Approval of details reserved by condition imposed under ref BR/63/19/PL relating to Condition Nos 3 - dustbin storage, 5 - renewable energy, 7 - material & finishes, 10 - Construction Management Plan, 13 - cycle parking spaces, 15 - visibility splays and 16 - pedestrian visibility splays

15-17 Kew Gardens Bognor Regis PO21 5RD

Condition Number 16

Project:-	Proposed Residential Development 15-17 Kew Gardens Bognor Regis West Sussex		
Title:-	Proposed Visibility Plan		
Client:-	Imperial Homes (Southern) Ltd		
Scale:-	1:100 (@A1)		
Drawn By:-	PJD	Checked By:-	
Date:-	09/01/20	Date:-	
Job.No:-	180037	Drg.No:-	15

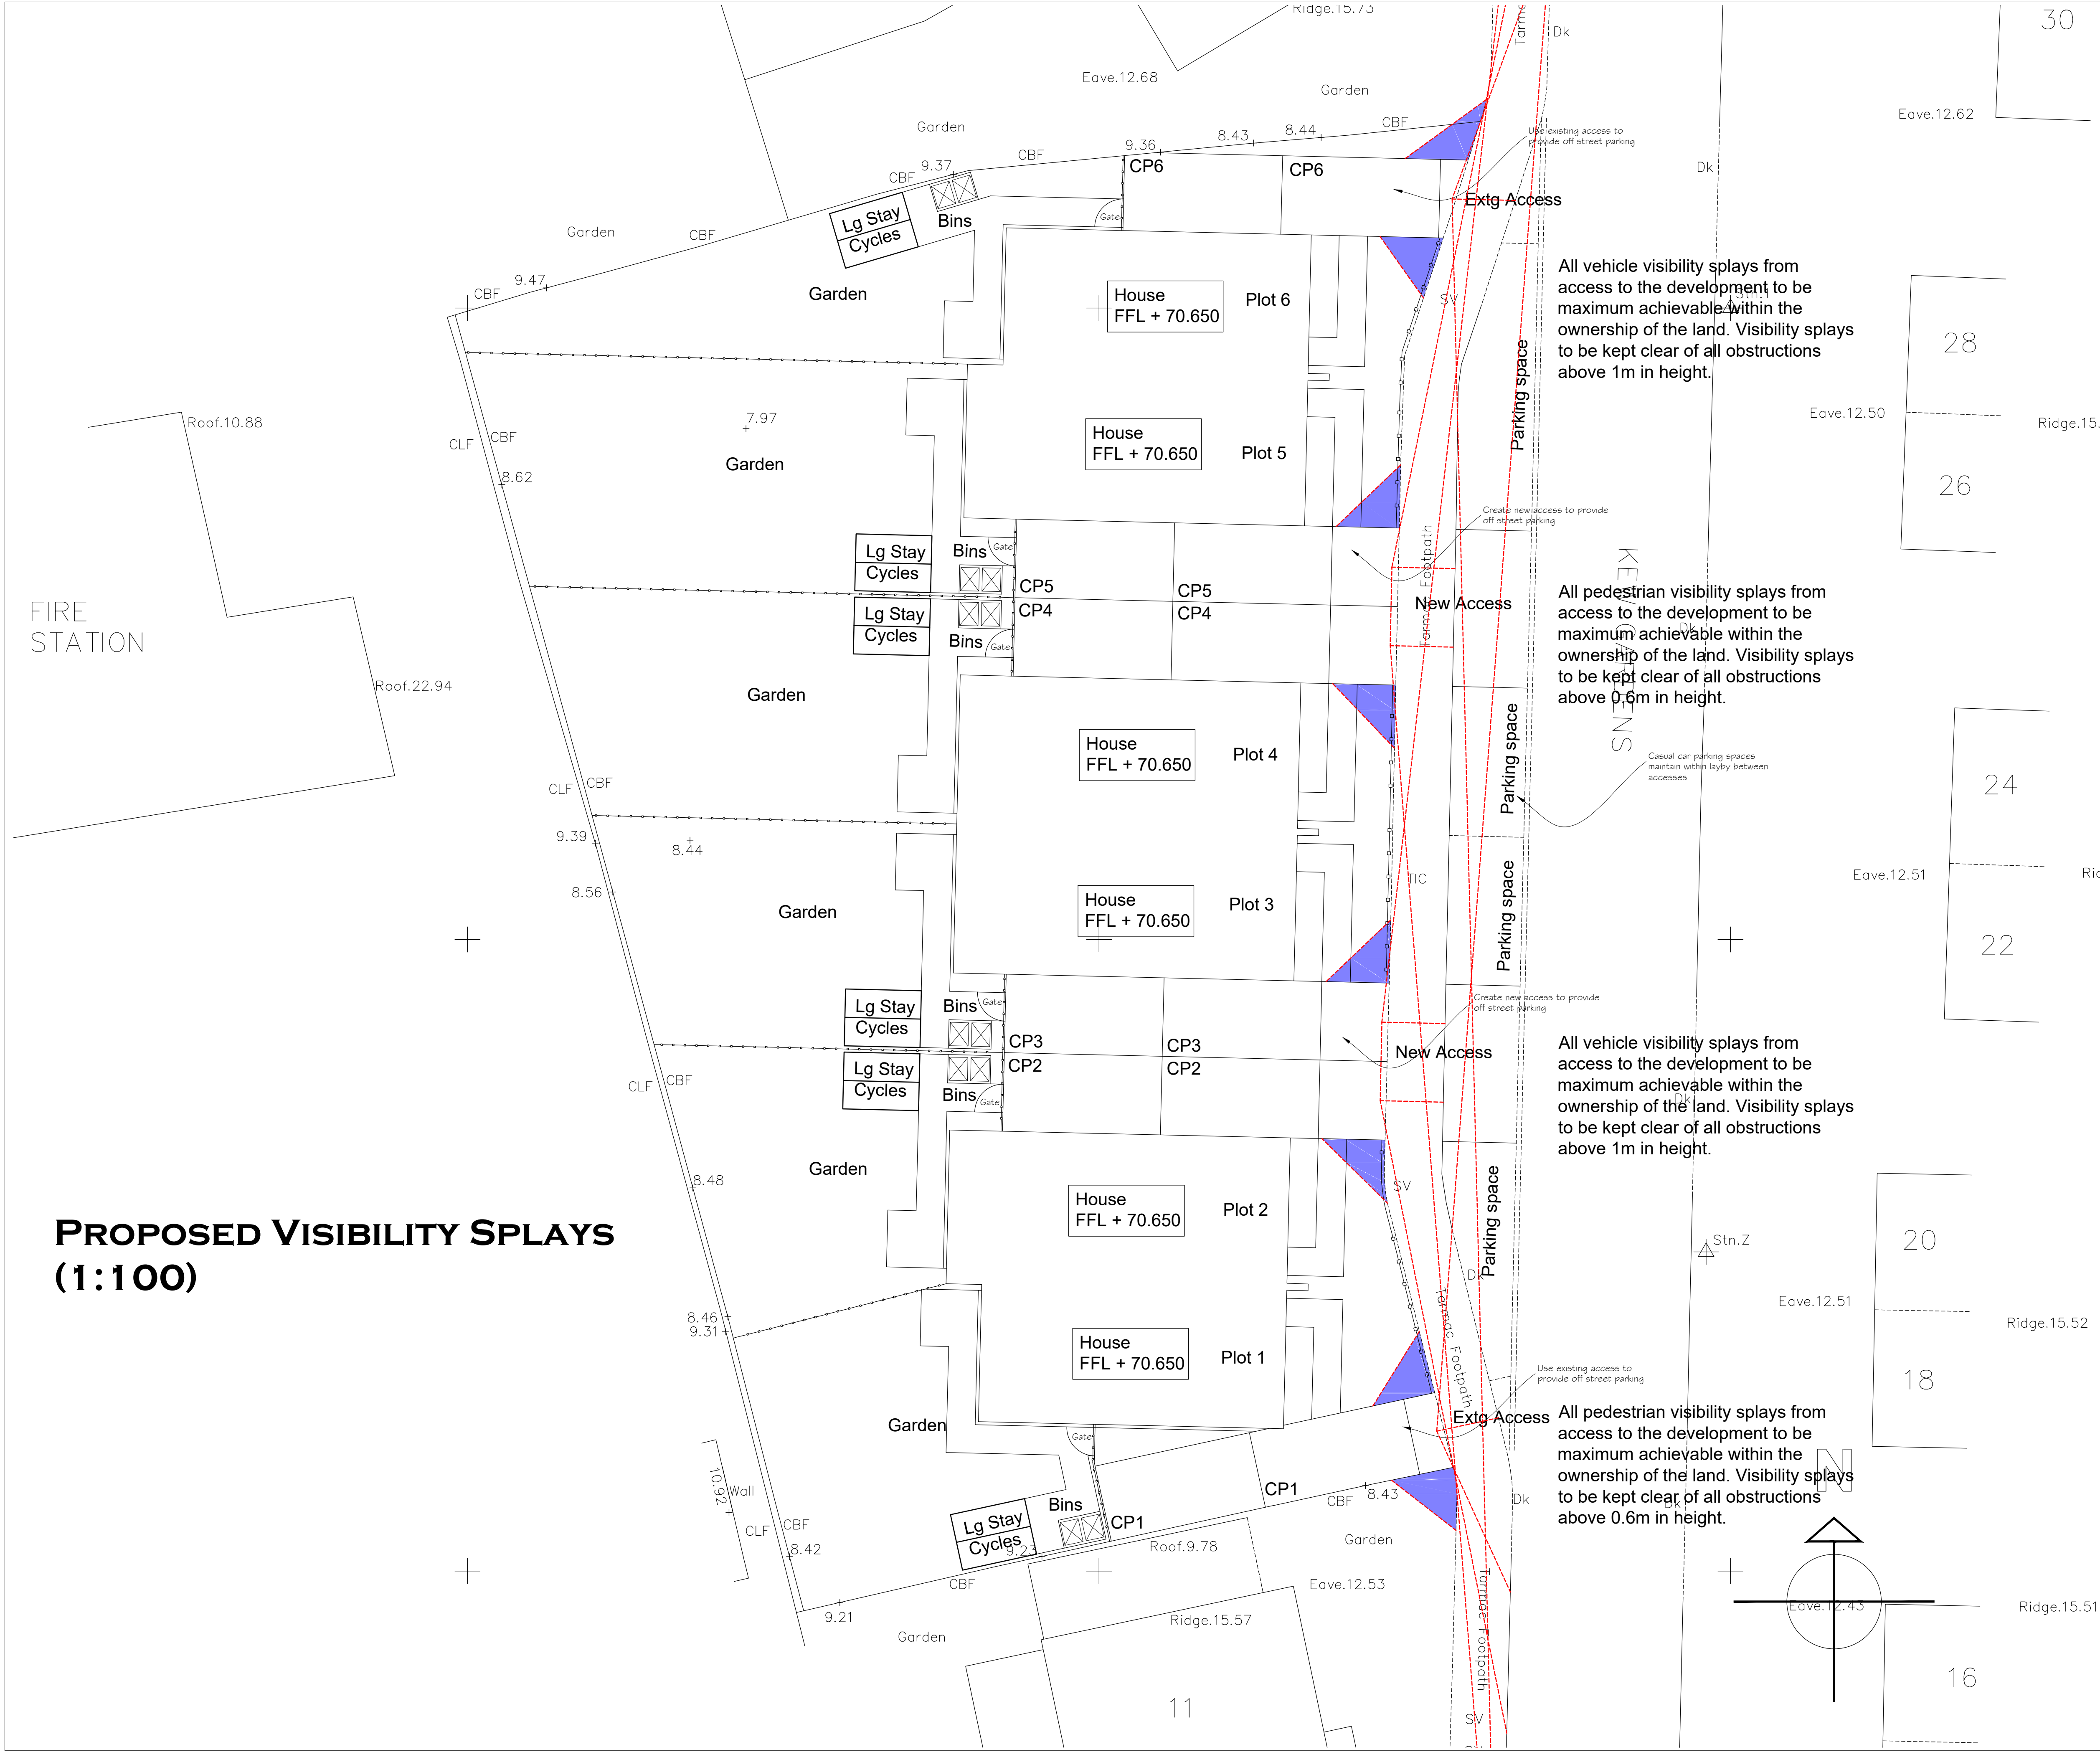
No part of the development shall be first occupied until pedestrian visibility splays of 2 metres by 2 metres have been provided or to best of ability either side of the proposed site vehicular access onto Kew Gardens in accordance with plans and details to be submitted to and approved in writing by the Local Planning Authority. These visibility splays shall thereafter be kept free of all obstructions over a height of 0.6 metre above adjoining carriageway level or as otherwise agreed.

West Sussex County Council Highways have been consulted and commented amended drawings: The extent of pedestrian visibility splays within red edge of site have now been made clear. The plans and details pertaining to condition 16 are acceptable.

Drawing No.15 Rev A, Proposed Visibility Plan, received on 06/04/2020

Therefore, the condition is fully discharged insofar as the submission of details relates and on the understanding that demonstrated pedestrian visibility splays will be permanently maintained.
